CITY OF ALBUQUERQUE

RE: 5720 McMahon Blvd NW –McMahon Market Place New Shell Building
Grading Plan and Drainage Report
Stamp Date: 9/15/17
Hydrology File: A11D011H

DRAINAGE AND TRANSPORTATION INFORMATION SHEET (REV 09/2015)

RE: McMahon Market Place LOT 5A and 6A1 – TAP ROOM AND RETAIL SHELL BUILDINGS

### PROPOSED STORM DRAIN SYSTEM

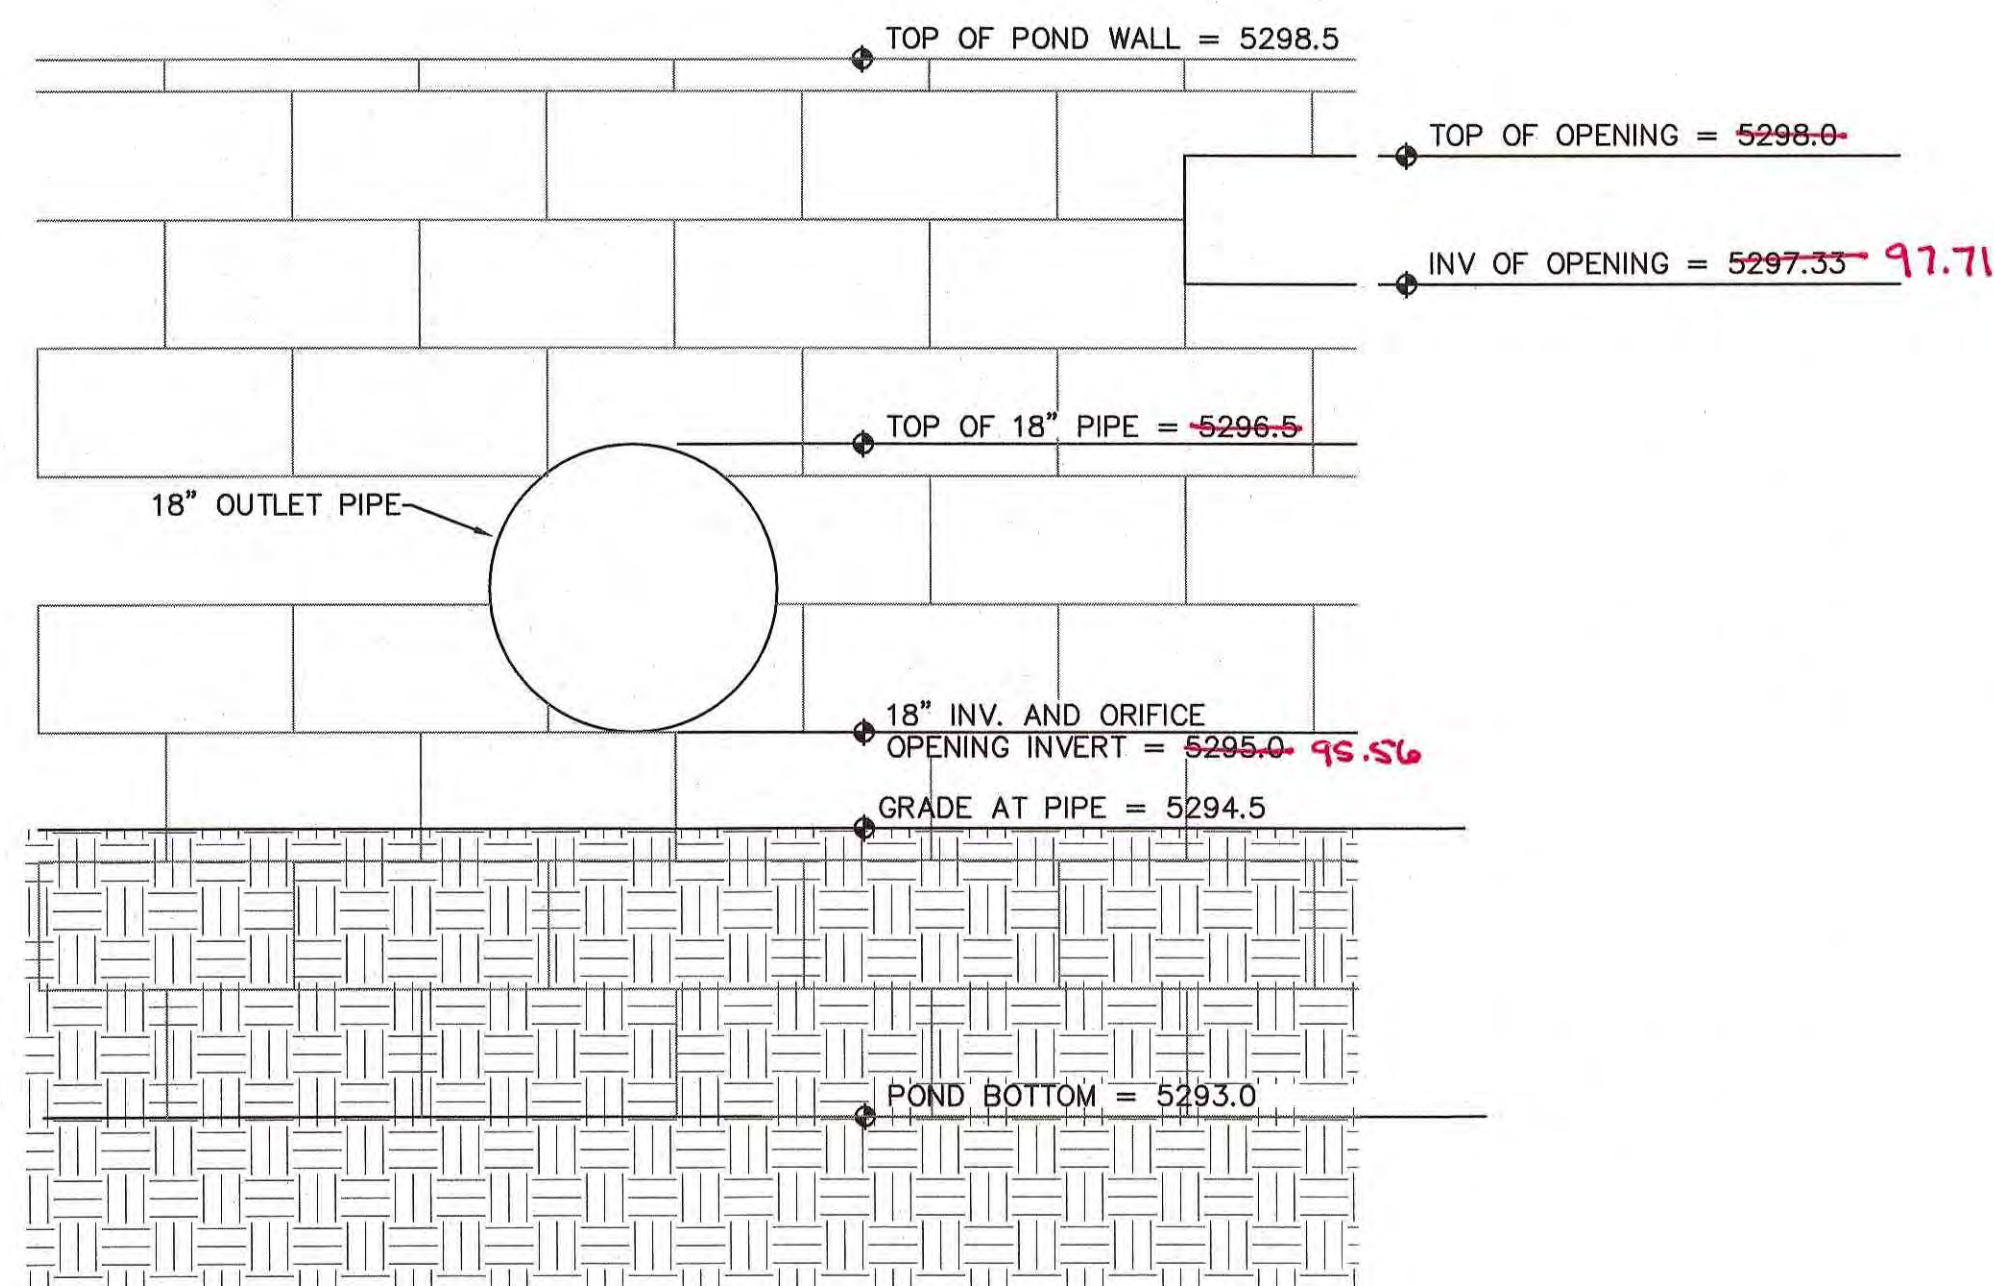
What is the future Lot 9 discharge in the storm sewer system? Are you sure that an 18 inch pipe will be able to handle the discharge from Lot 9 and this tract? I would have expected to see a 24 inch pipe.

I am reviewing this project and have only one comment. What is the pipe size for the private storm drain. I do not see the sizes on the Proposed Storm Drain System on Sheet CG-2. Please add the pipe sizes and then email me a pdf of the sheet with the engineer stamp date of 9-15-17. I will then send you the approval letter. Don't forget to include the drainage of the future Lot 9 so that the storm pipe to be installed can handle the all future flows.

Per the calculations provided, the pond is permitted to discharge max 17.65 cfs in the fully developed condition to limit the discharge to 41.55 cfs. The pond is not able to detain the difference so, as Lot 9 develops, detention will be provided.

The 18" diameter system is sufficient for the required Q although a 24" would be needed if detention were not required on Lot 9.

Attached is the revised sheet CG-2 with the pipe sizes shown.
